Development Facilitation Team (DFT) – Review Comments

Project No: PR-2022-007324 Date: 6/28/2023 Agenda Item: #8 Zone Atlas Page: J-13

Application For: VA-2023-00129-Sidewalk Waiver (DHO)

Project Name: 2100 & 2124 Central Avenue – Champion Car Wash

Plat of
Lots A and B, Block 4
Traction Park & City Electric Addition
Section 18, Township 10 North, Range 3 East, N.M.P.M.
Albuquerque, Bernalillo County, New Mexico
October 2022

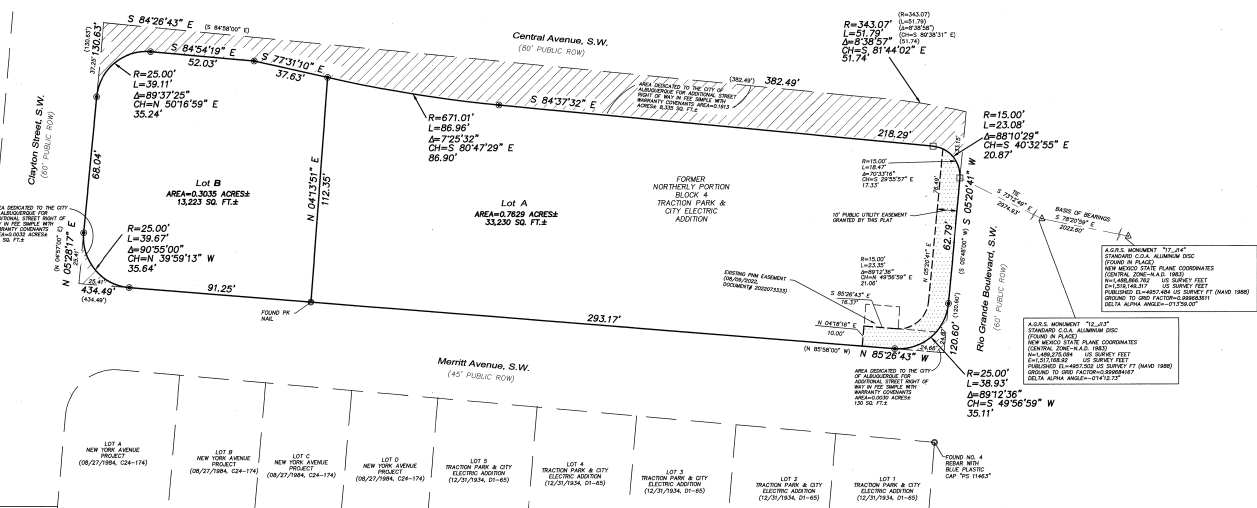
- **If the waiver is approved, a note of the waiver approval must be added to the Preliminary/Final Plat that is under review with the DRB.**

LANDSCAPE LEGEND

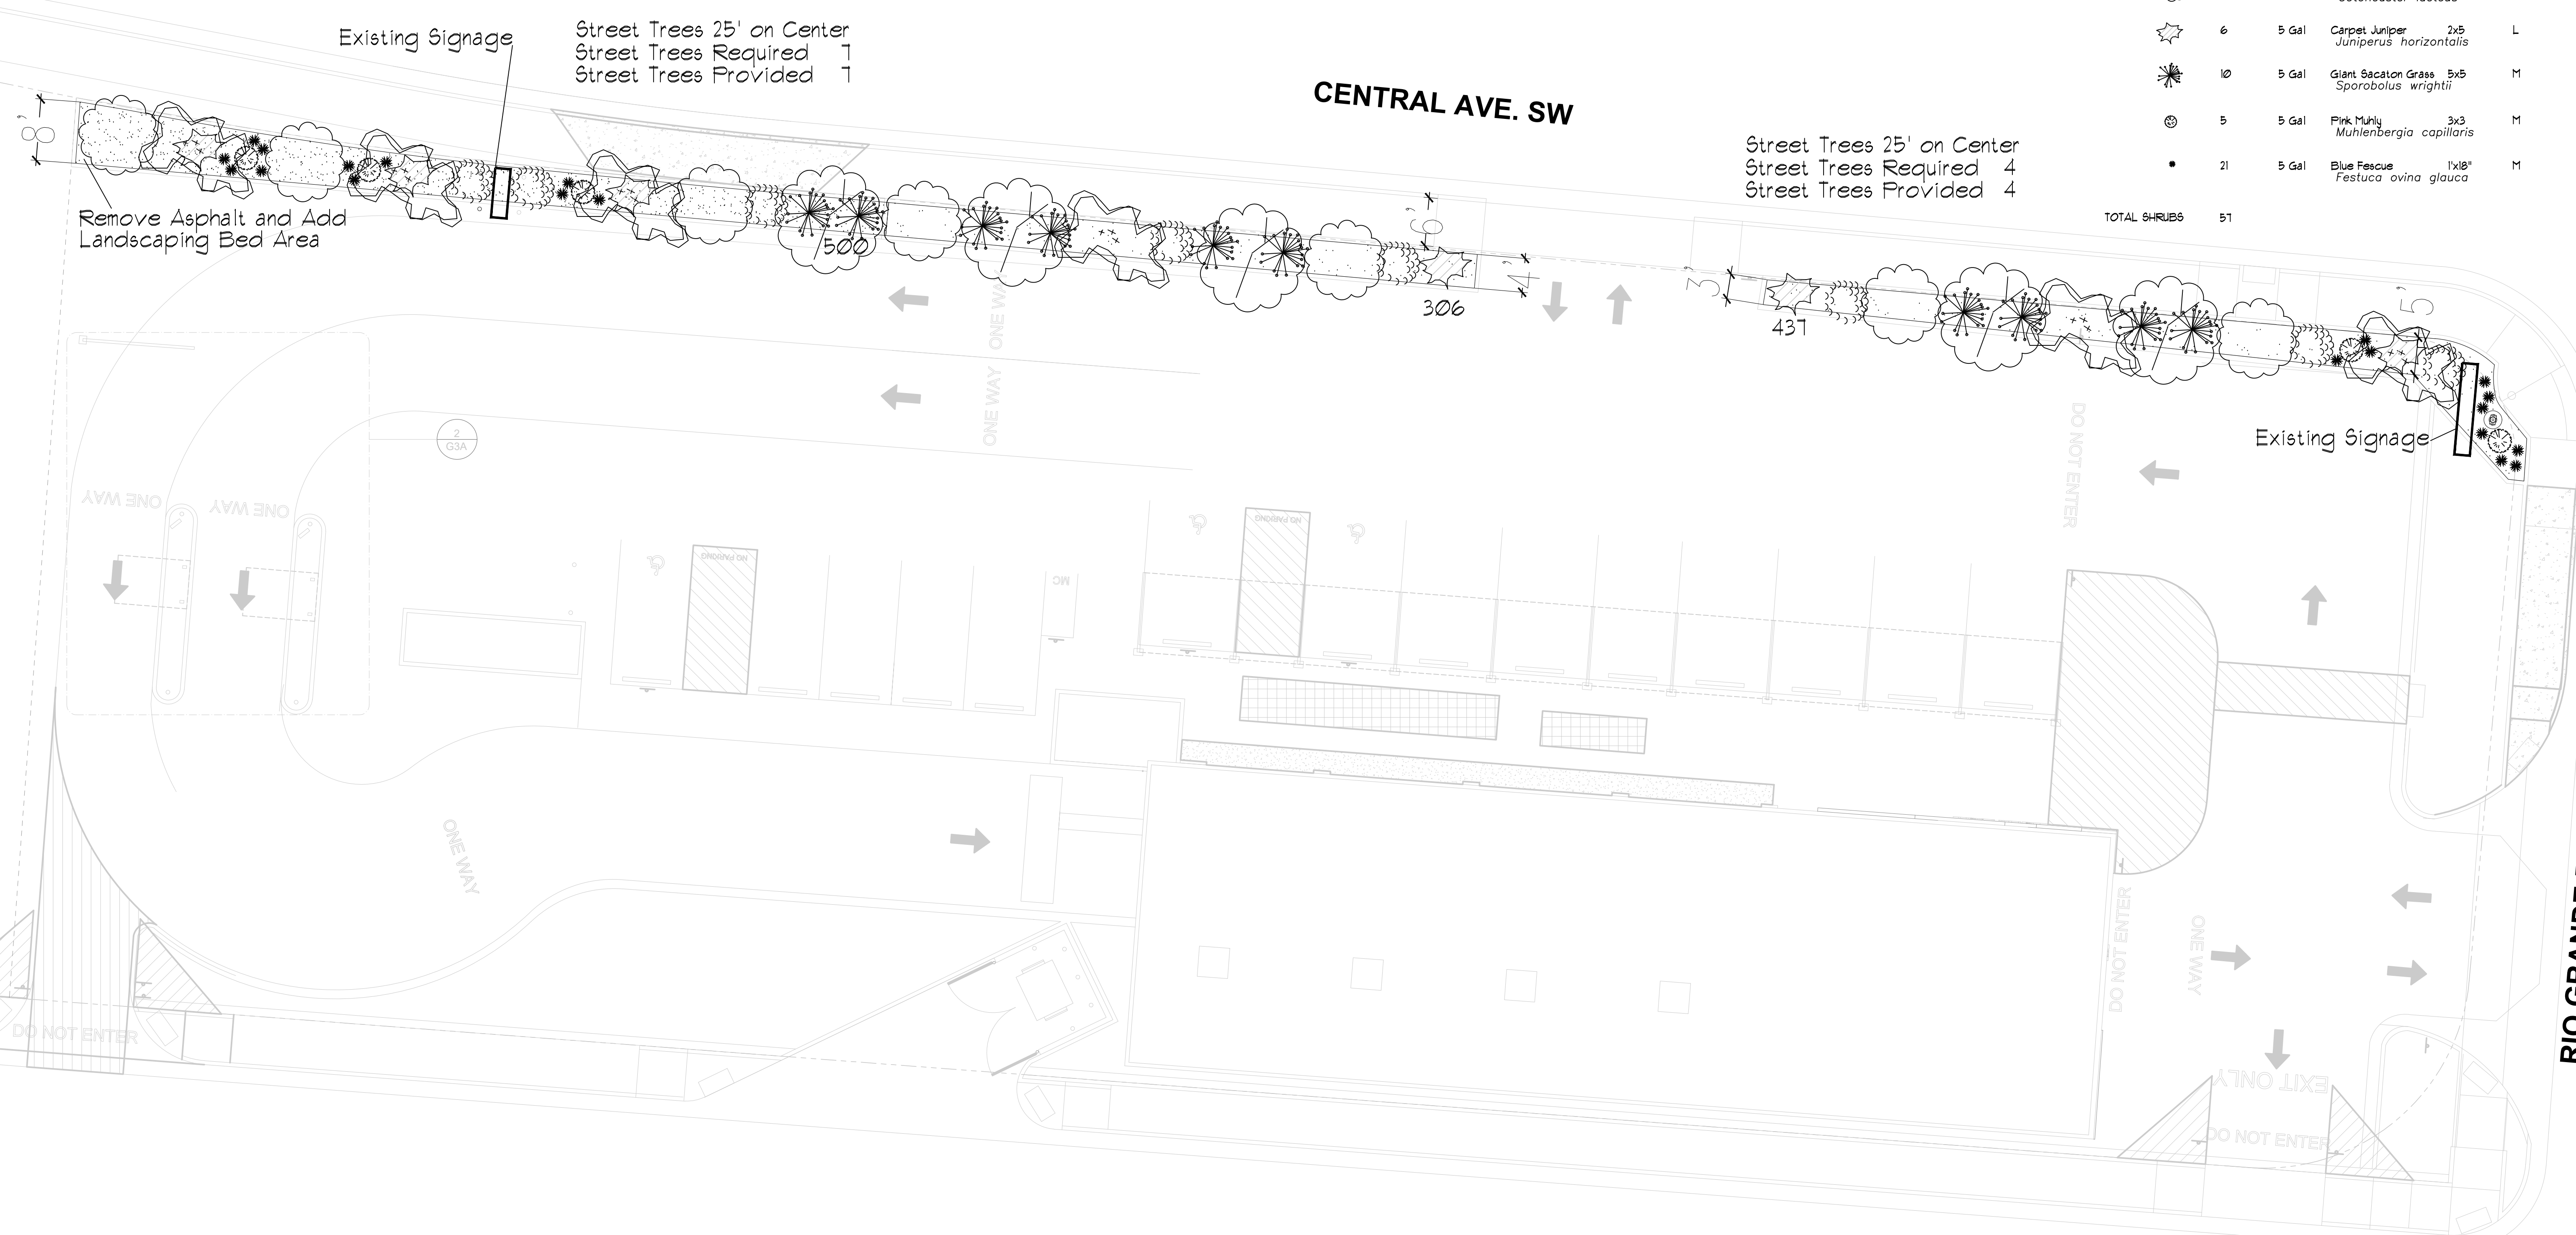
The landscaping plan submitted *does not* include the western parcel (also along Central). The purpose of the plat before the DRB is to separate the western portion which has an unoccupied restaurant from the eastern portion which is a car wash. The streetscape frontage along the restaurant has a tapered landscape buffer between the curb and the

Previous comments had no objections to the waiver. Required street trees can be planted within 20 feet from the back of curb. Regarding the 4' foot landscape buffer along Central as desired by the N.A. is not ideal for street trees. After speaking with the City Forester, while trees as close to the sidewalk and street are preferred in meeting the intent – many urban trees have not lasted more than five years due to lack of rooting space. PRD prefers a minimum of 5' for tree planting.
